## FINAL DRAINAGE REPORT

Foundation Lutheran Church

Townners Ave  
Tract C, Paint Brush Hills Filing No. 13A  
Falcon, Colorado

PCD File No. PPR2321  
JOB NO. 191726

Appendix C – Drainage Maps

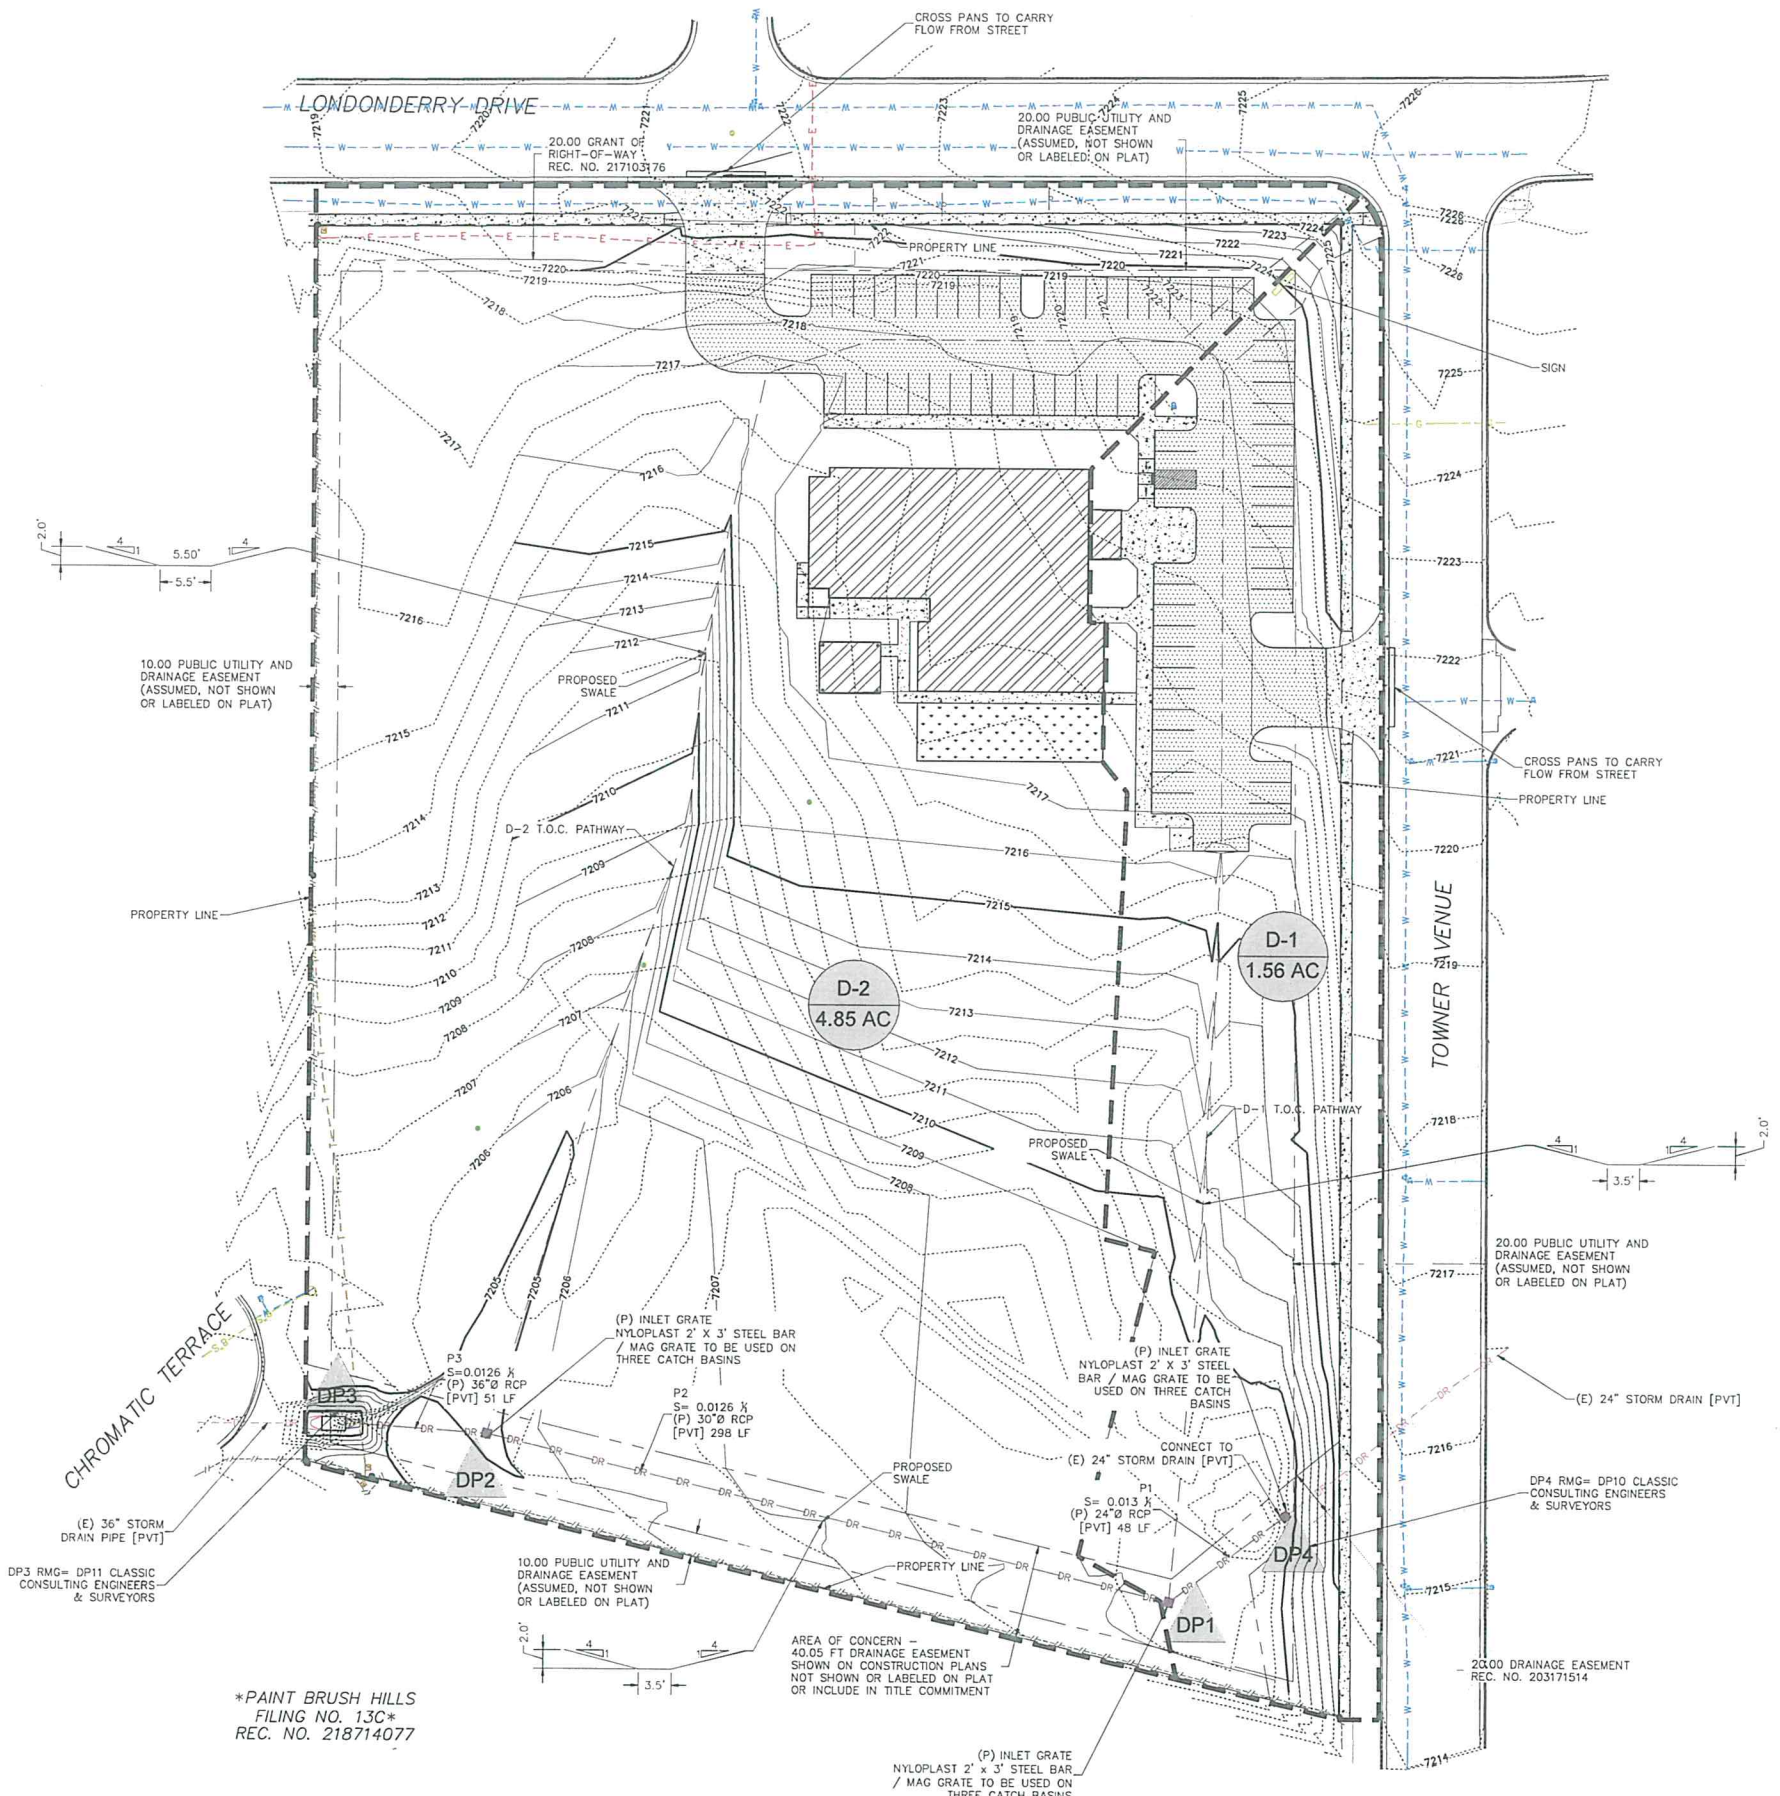
**Show and label on the drainage map where DP10 and DP11 are located.  
Or provide drainage map from previously approved report in the appendix.**

Unresolved from Submittal 1 - what are the proposed flows for DP3 & DP4? why were those removed from the text but are still shown on the maps?

Please verify runoff values shown match with the values shown on the drainage map.
